February 07, 2017

RE: 0 Valley Avenue – Permit #2016-02734

Please see our responses below to your Request for Clarification for the above reference project.

**PROPOSED SECTIONS  
& FRAMING PLANS**

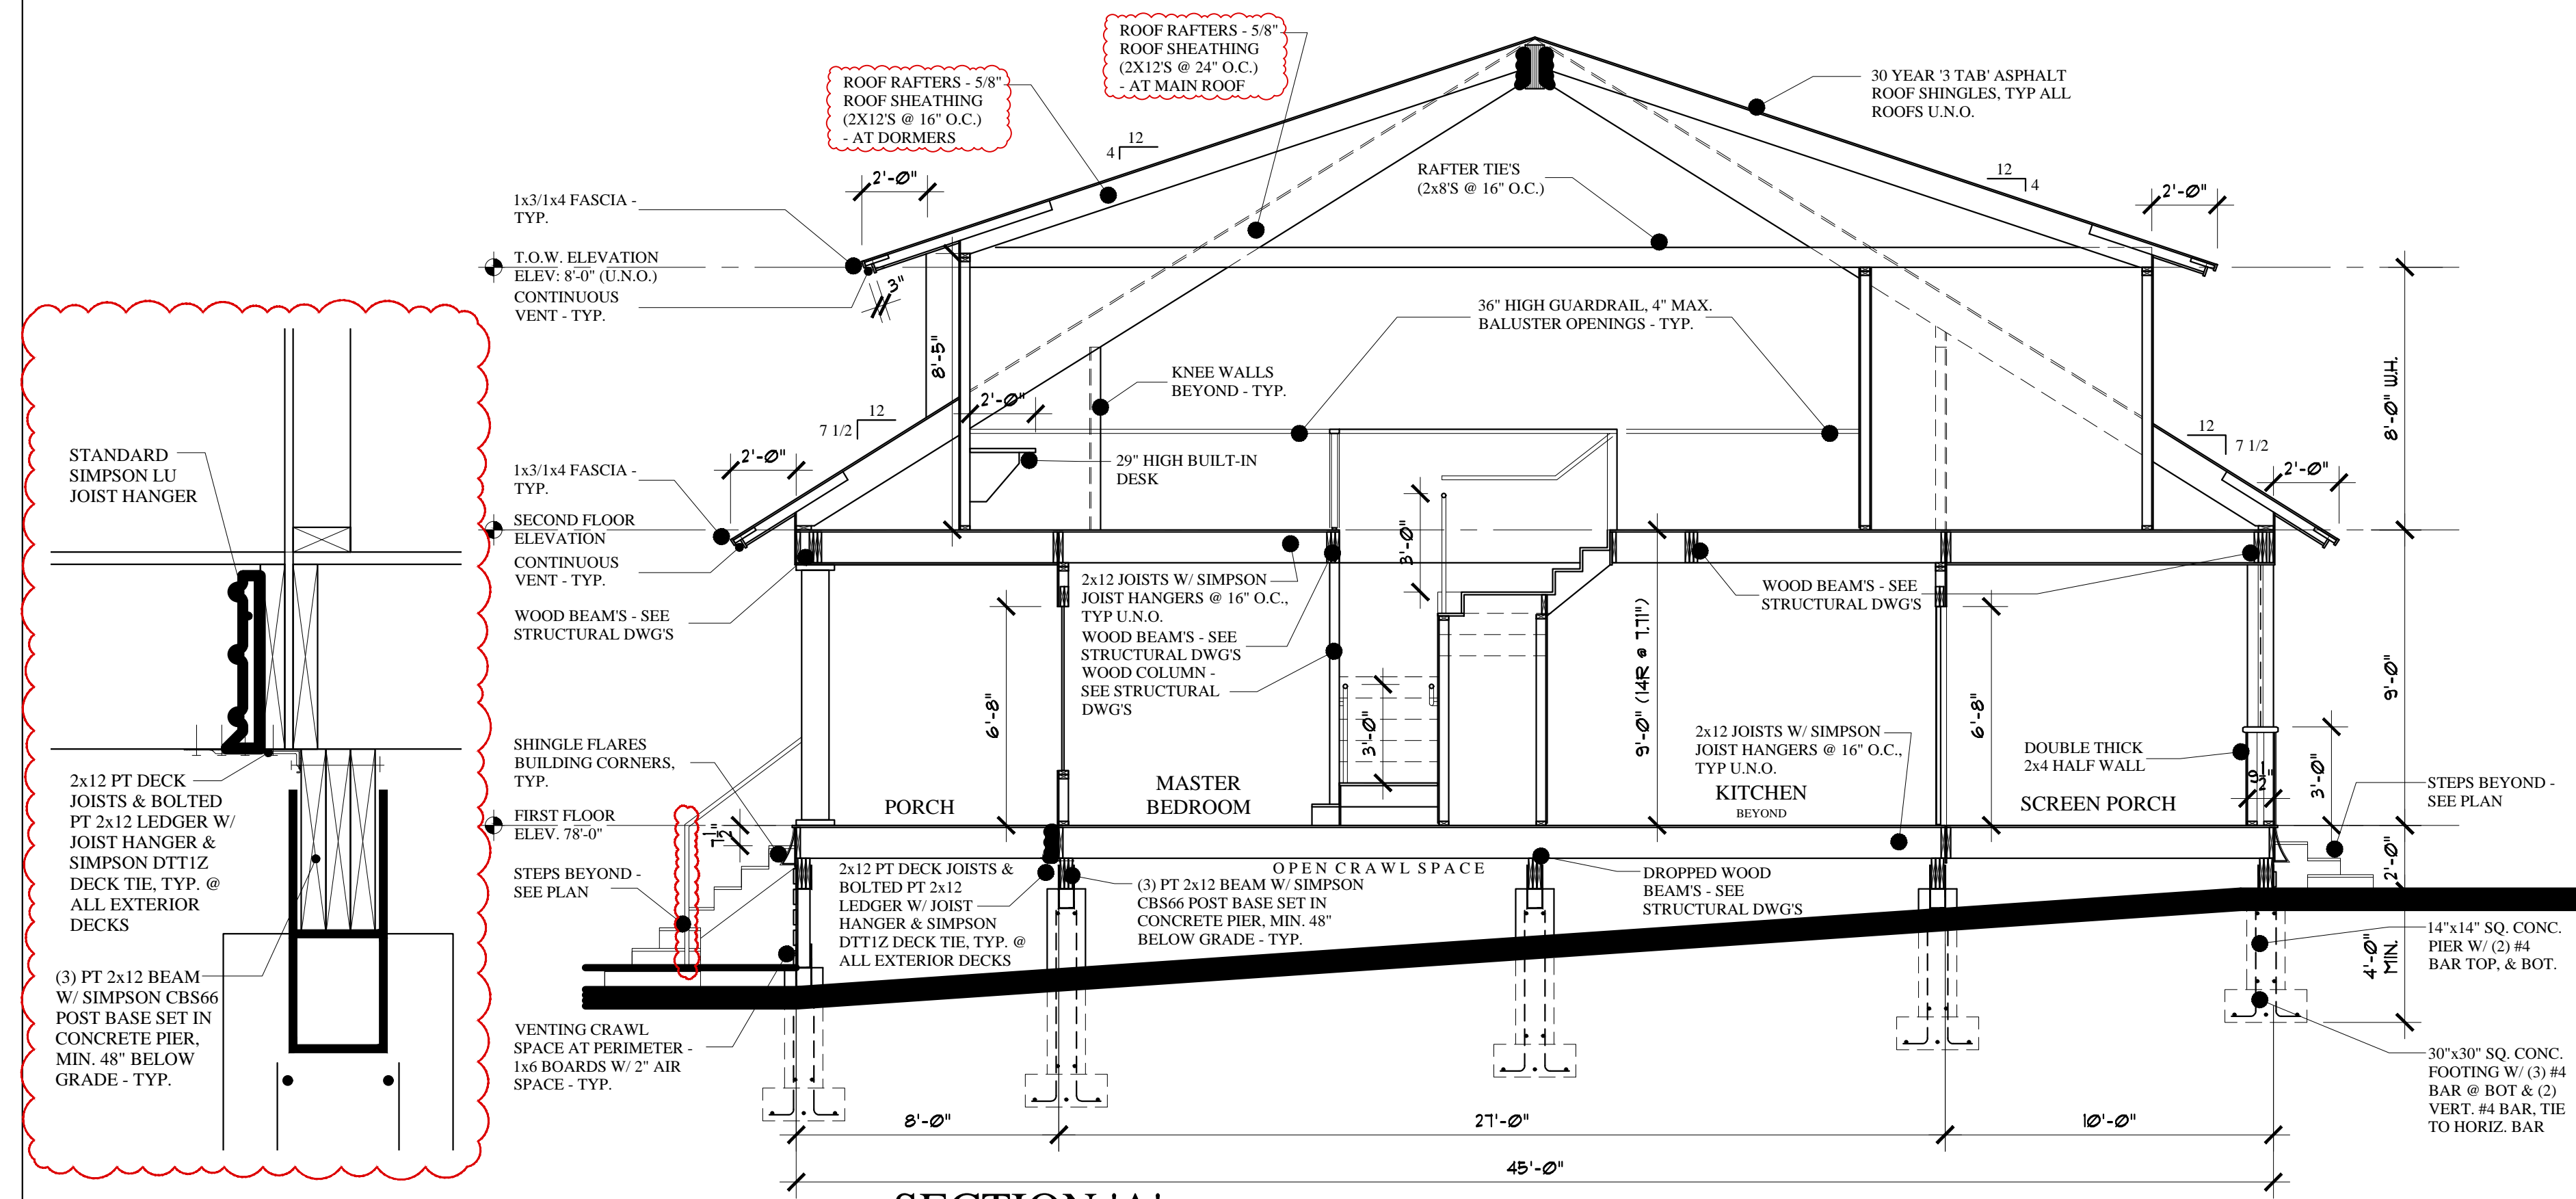
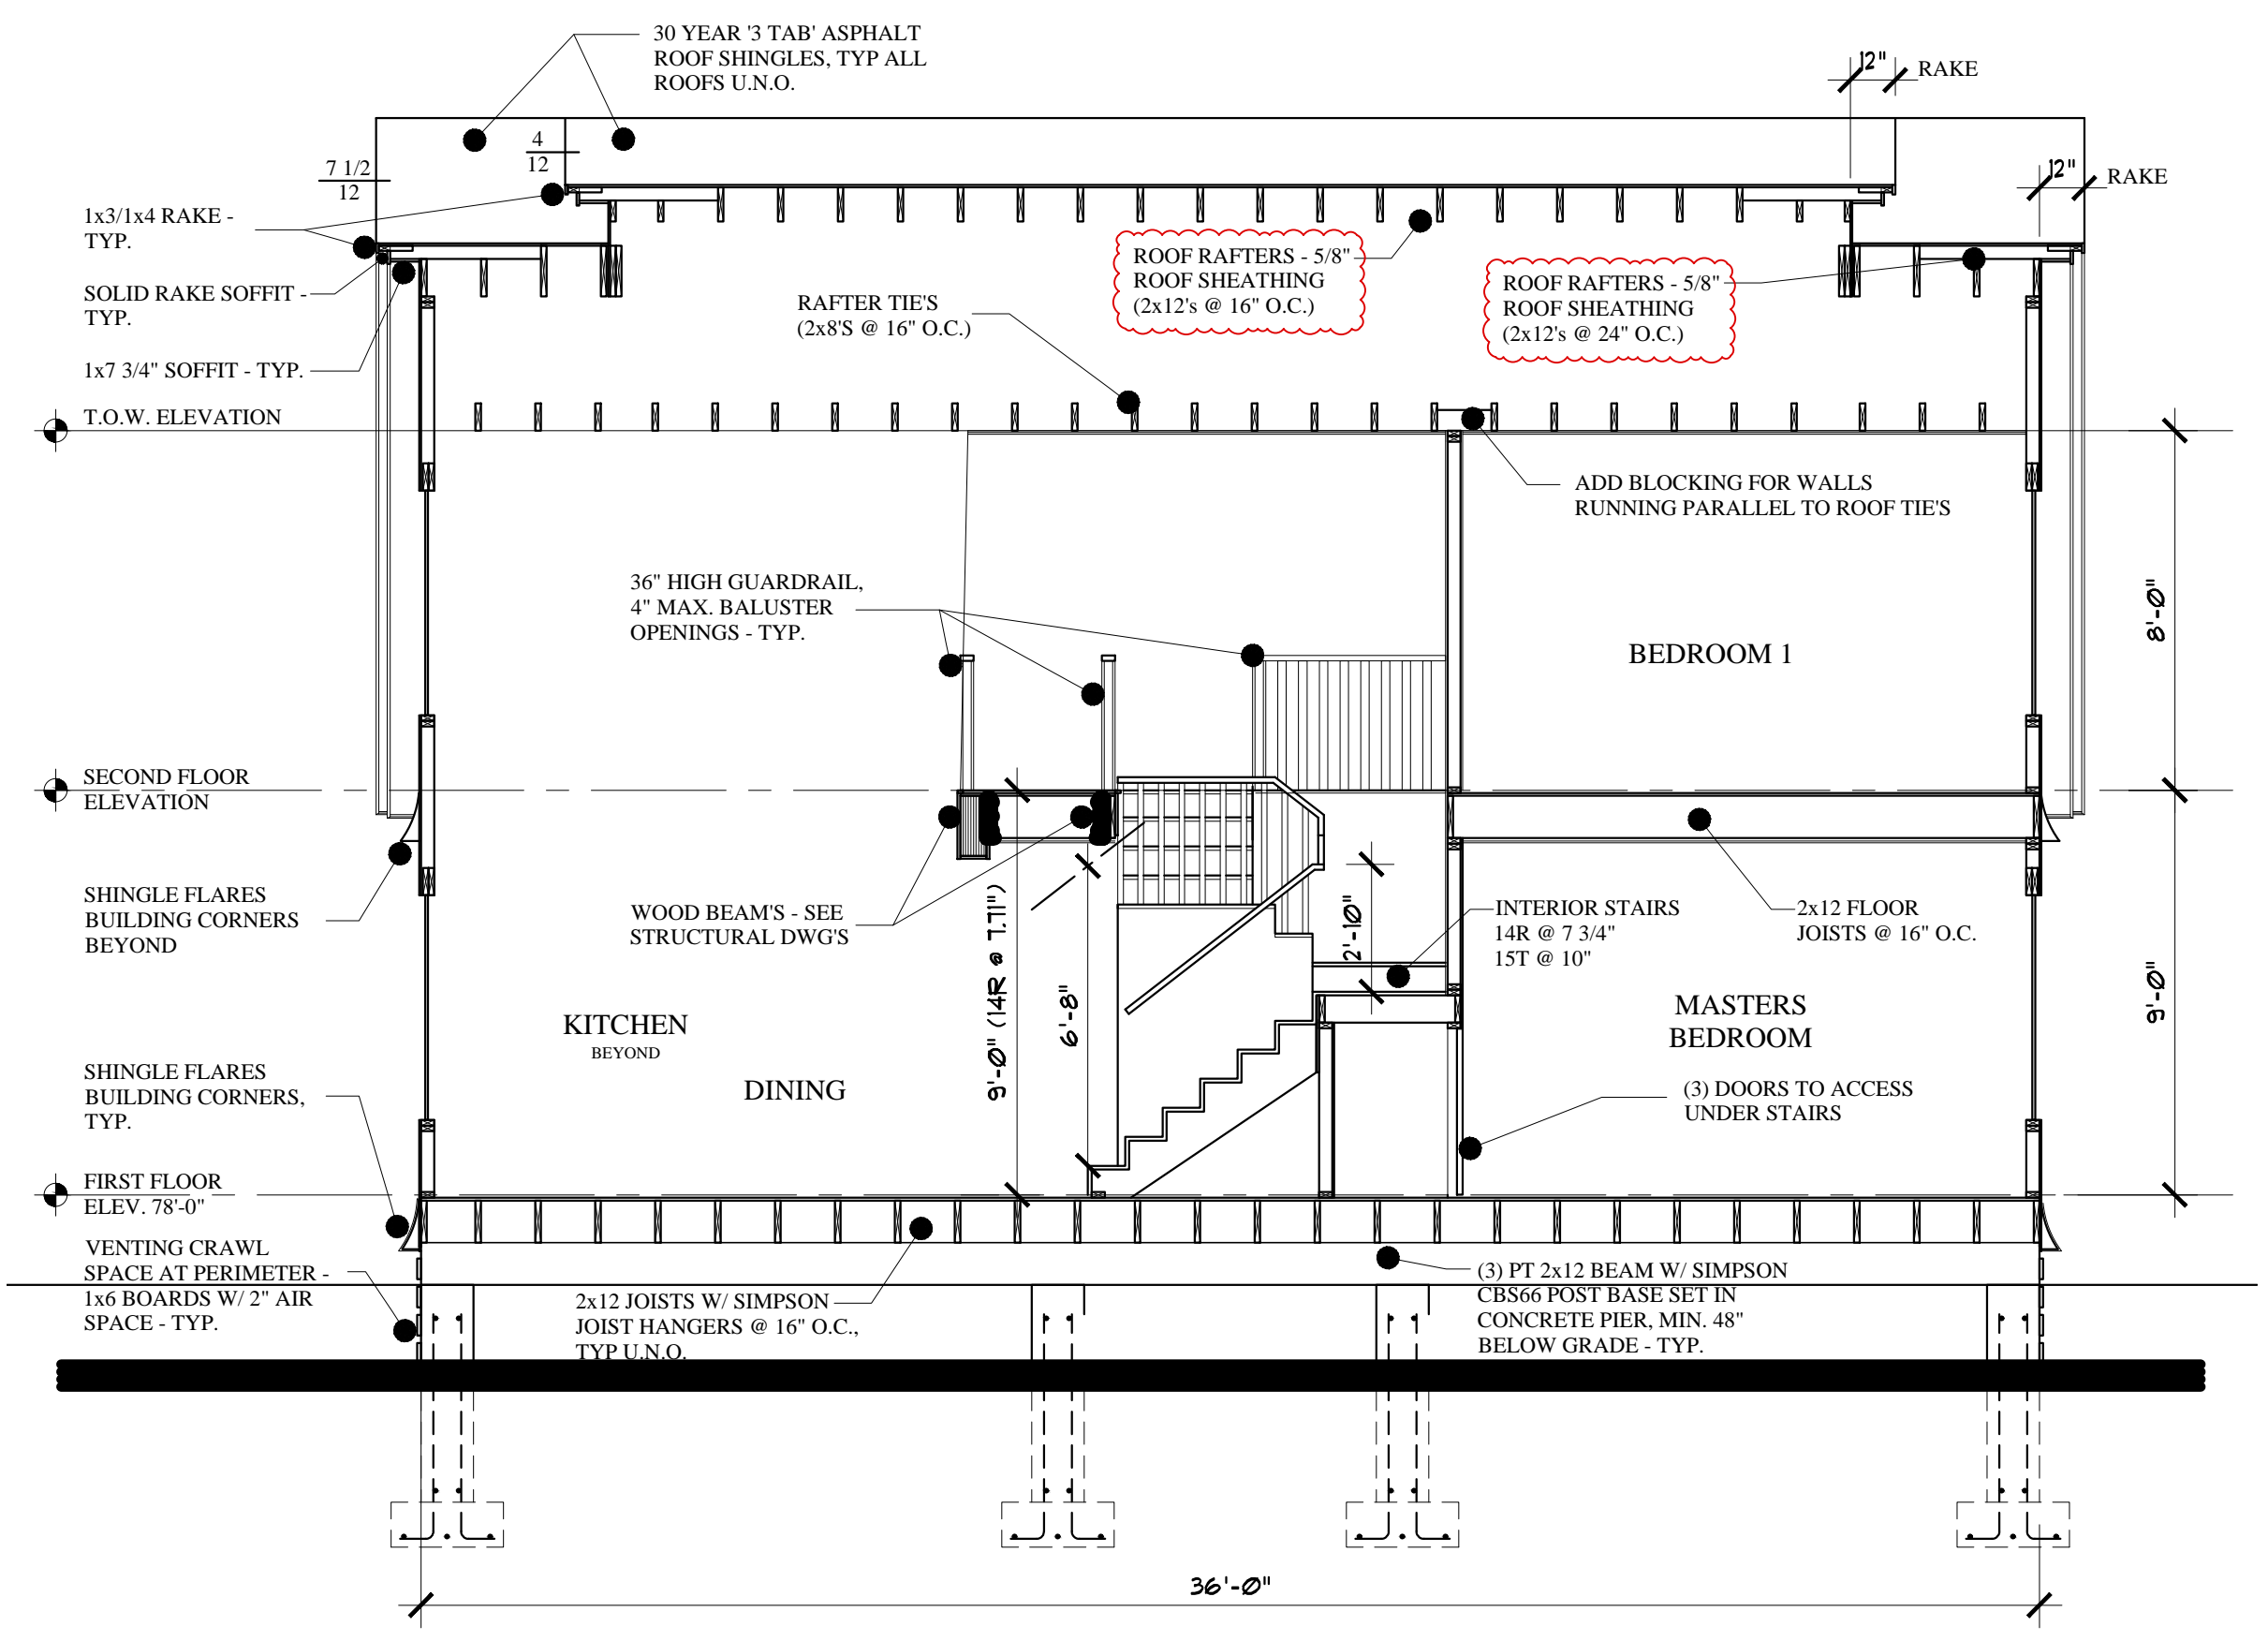
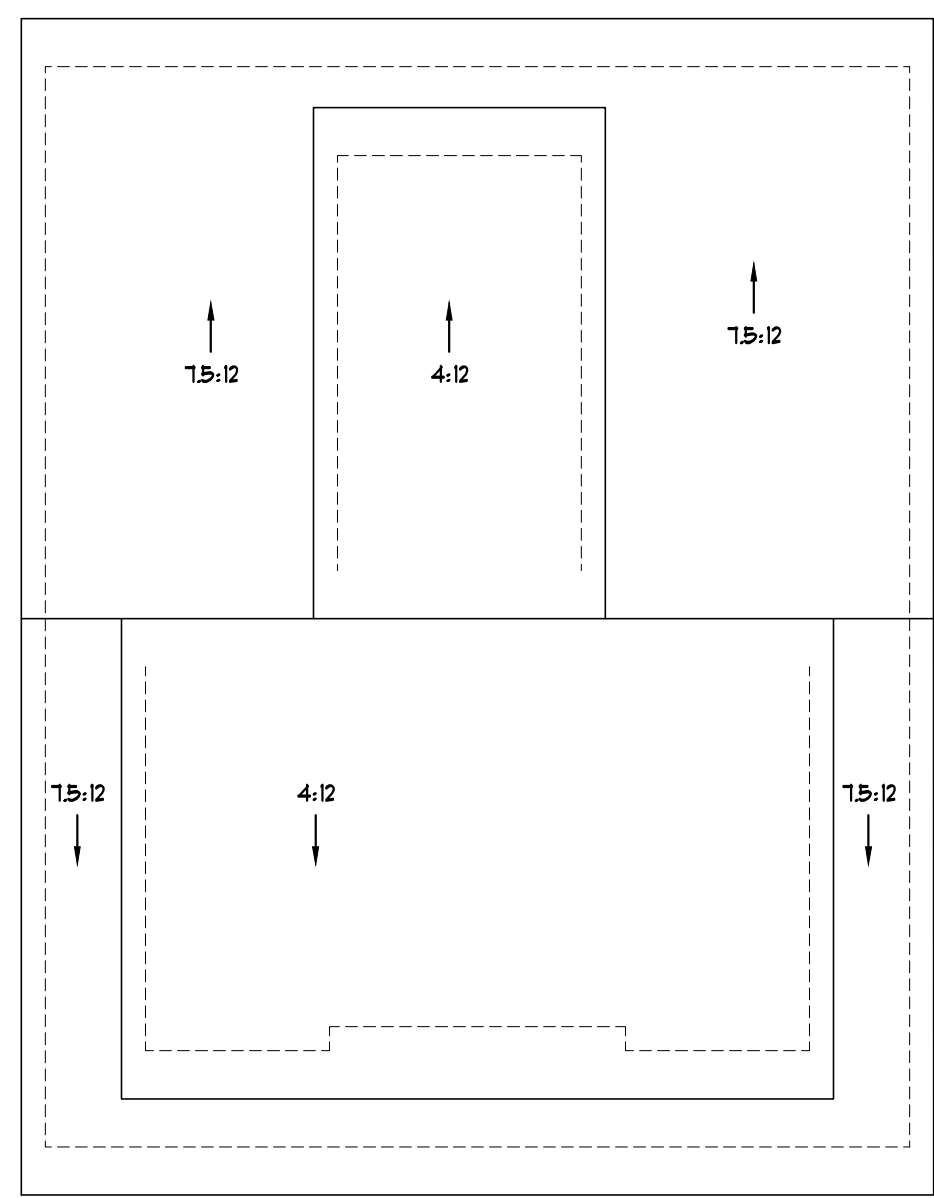
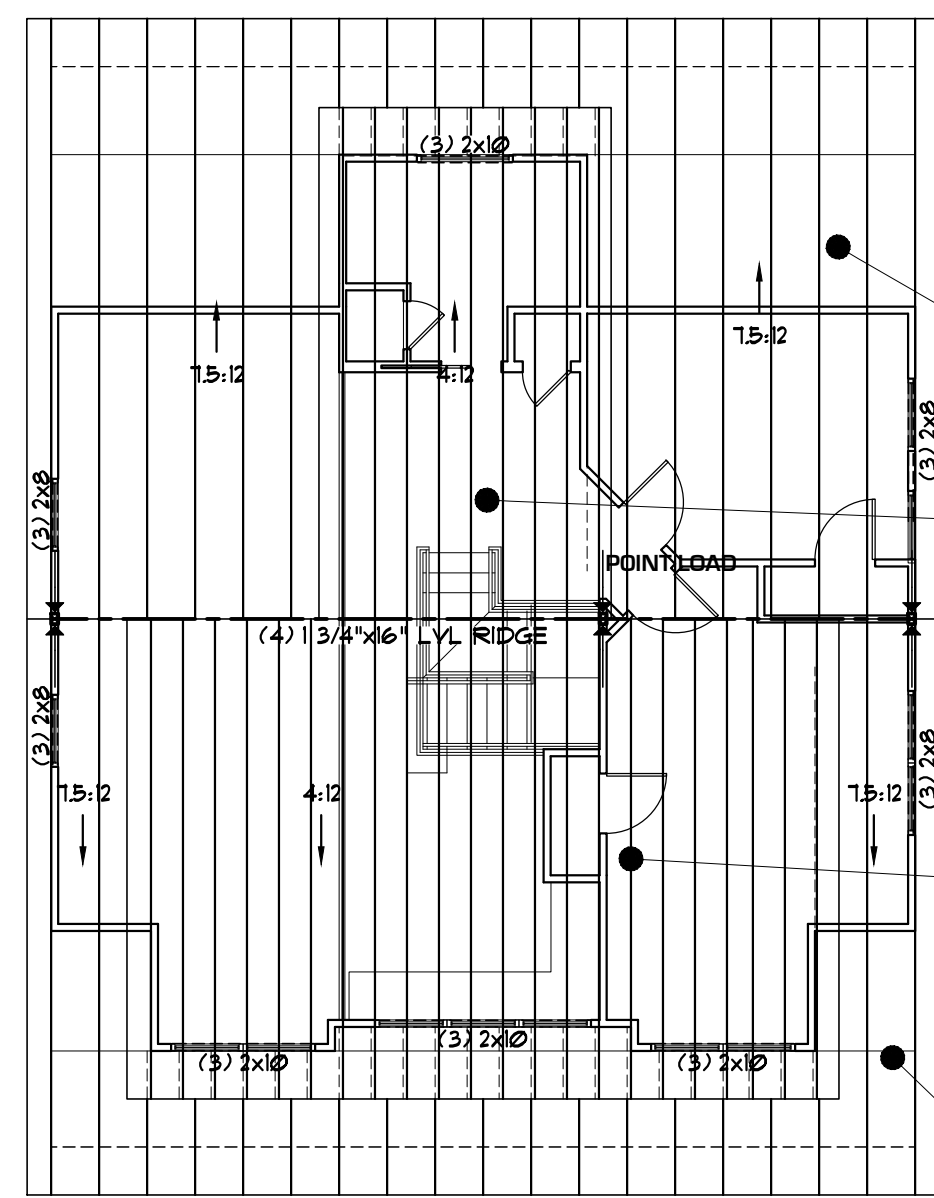
1. What is the Depth of the Footing?  
*48" below grade to meet min frost depth.*
2. What is the maximum length of the Joists on the second floor?  
*12'-6" unsupported – maximum length = 17'-0" (load bearing wall at mid span, see revised note on A-3.1).*

7. Provide window and door schedule.  
*Please see revised note on A-1.1.*
8. Provide header schedule.  
*Please see revised note on A-3.1.*
9. Show or call out locations or CO2 and smoke detector.  
*Please see locations on A-1.1 noted as 'SD/CO' located outside sleeping rooms.*

10. Provide deck connection and support details.  
*Please see detail on A-3.1.*
11. Handrail Continuity.  
*Please see revised handrail on A-1.1.*
12. What is the maximum length of the roof rafters?

*19'-0" unsupported – maximum length = 19'-3" with SPF #1 @ 16" O.C.  
Please see revised note on A-3.1 (load bearing wall at mid span, see revised note  
on A-3.1).*
